## Defence Infrastructure Organisation

### Highways England A303 Stonehenge (Amesbury to Berwick Down DCO application) TR010025

I am writing to provide Defence Infrastructure Organisation comments on behalf of the Ministry of Defence (MOD) on the Applicants proposed A303 Amesbury to Berwick Down DCO application.

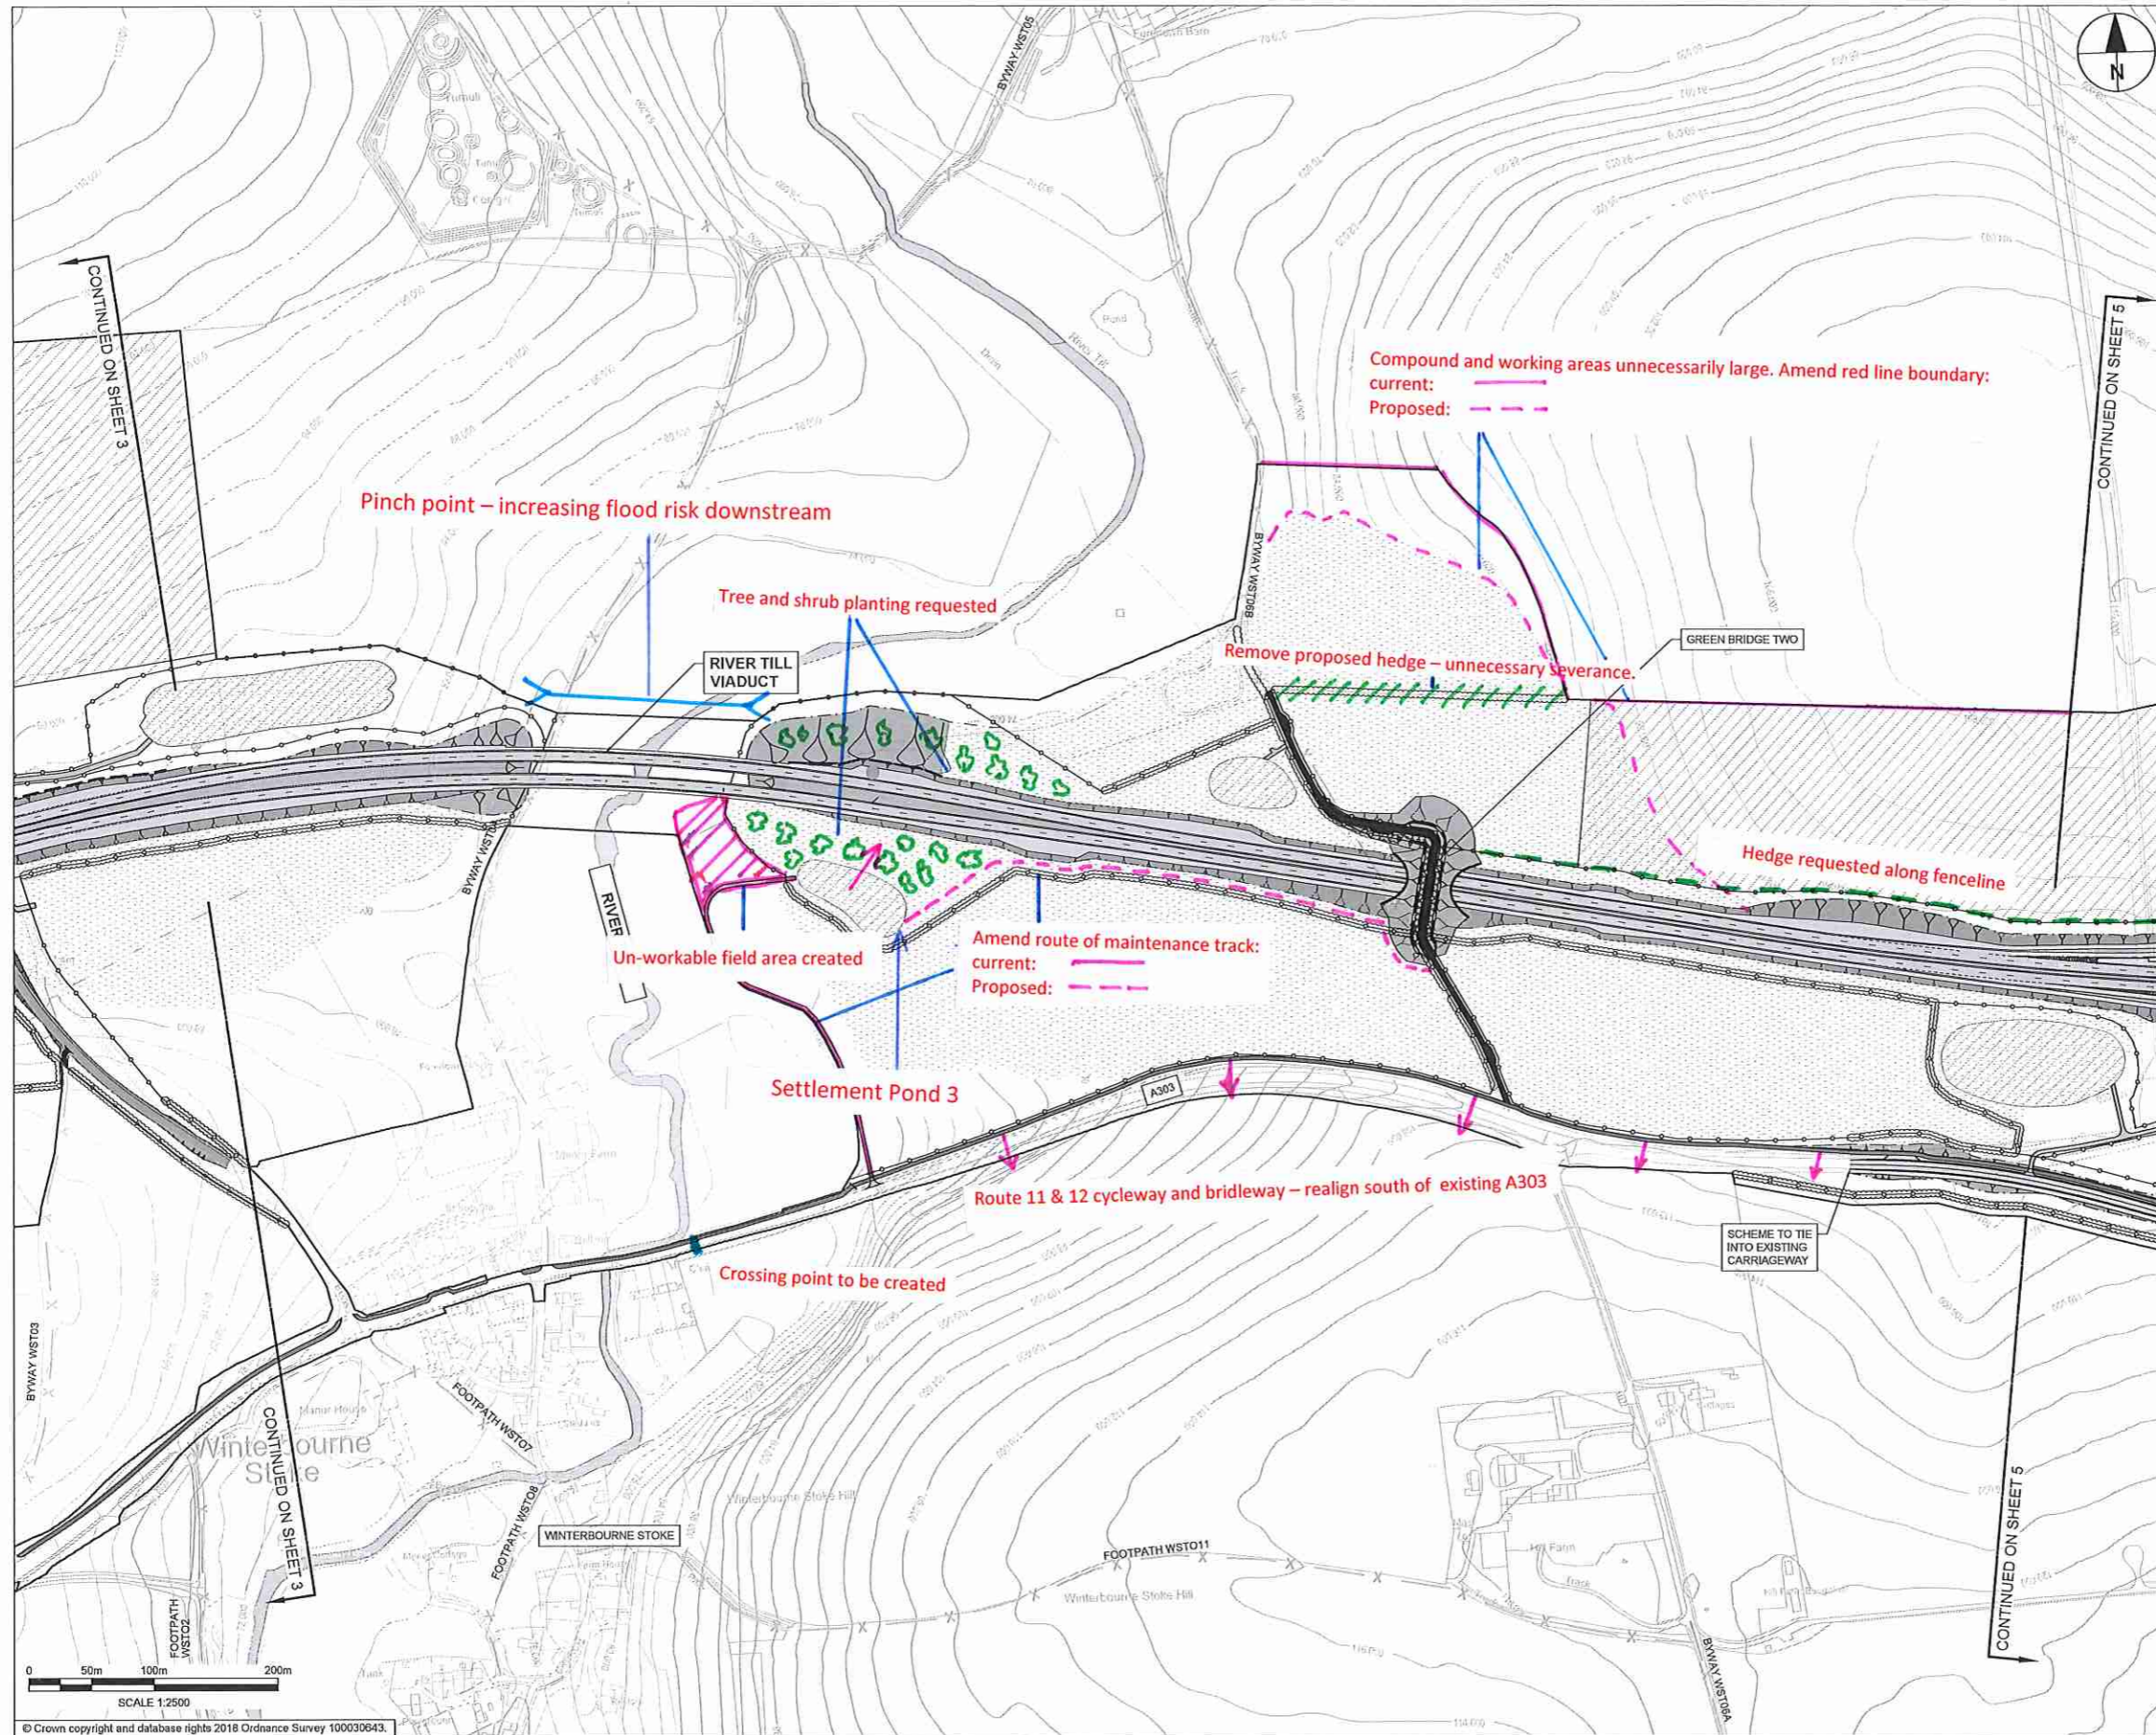
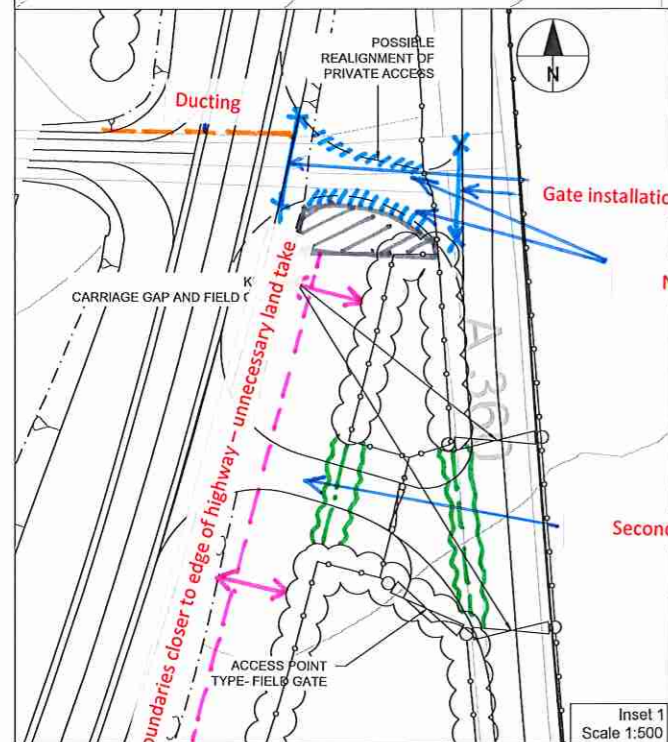
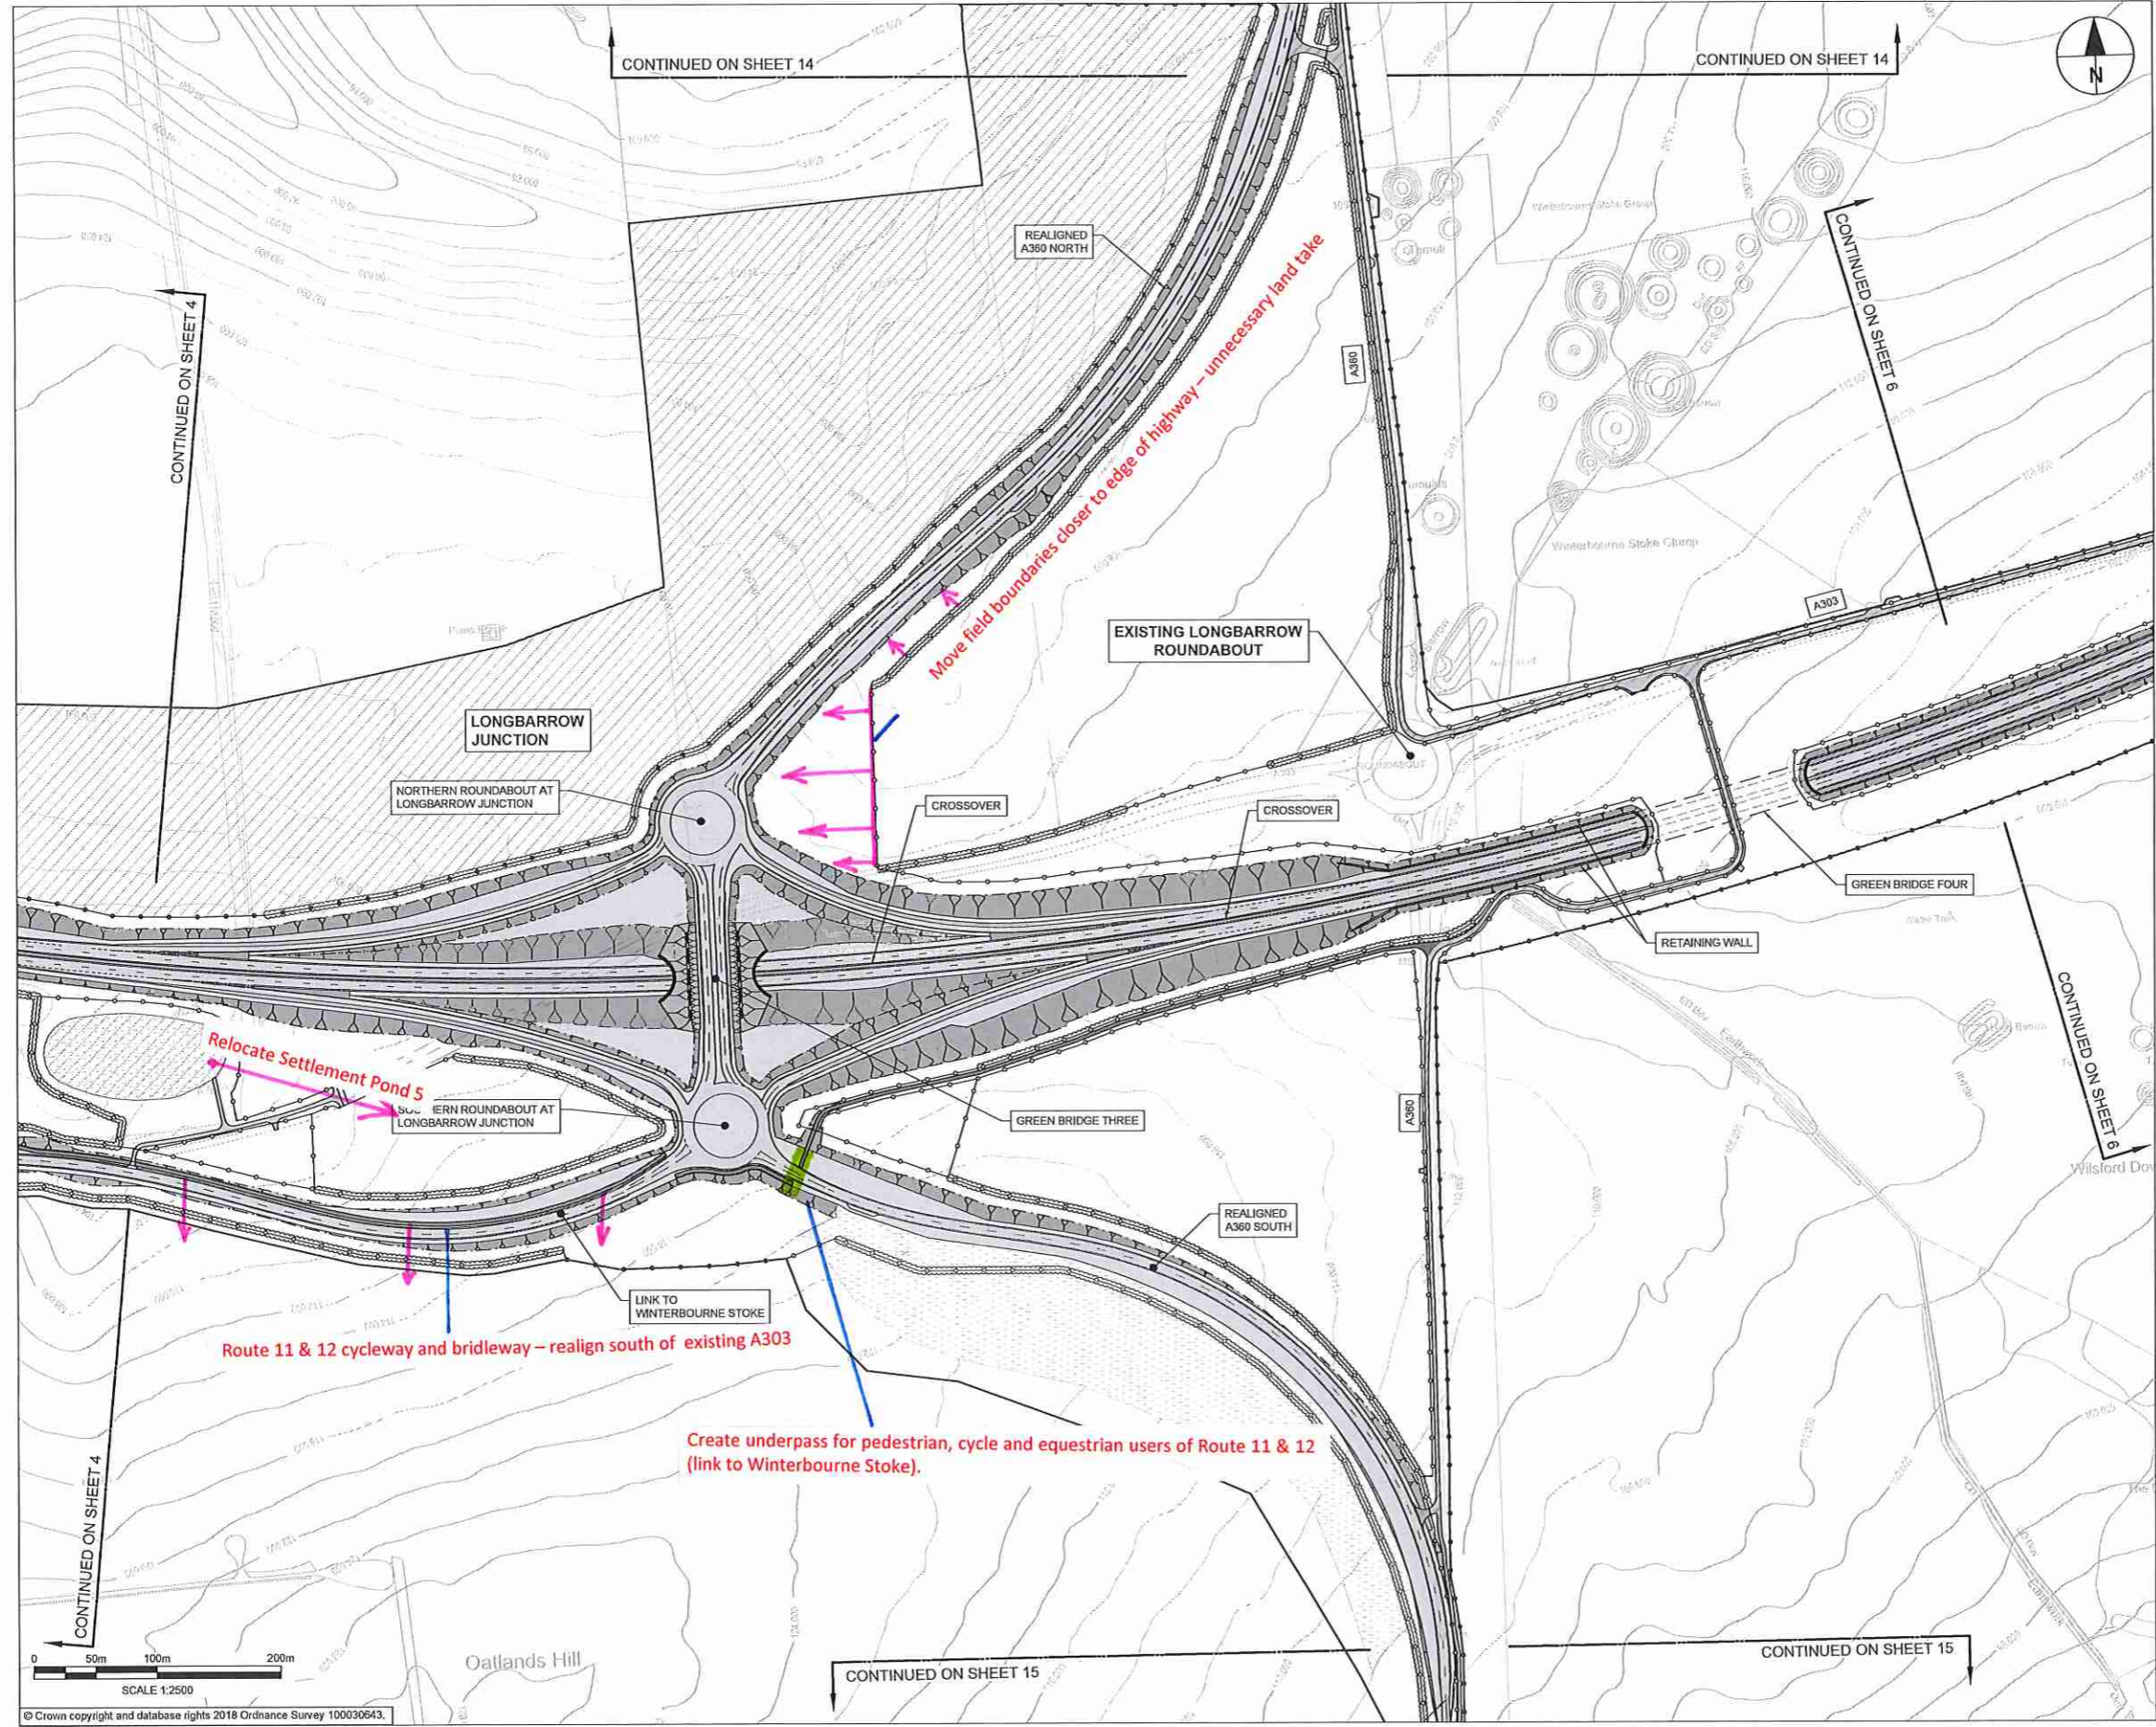
On reviewing the general layout arrangements documents the MOD have identified the key structures to the west of Amesbury on sheets 1-5 of the General Arrangements Drawings that occupy the 91.4m aerodrome height safeguarding zone surrounding Boscombe Down. The proposed elevations are under 30m AGL and do not infringe our criteria, we therefore have no aerodrome height safeguarding concerns in this remit.
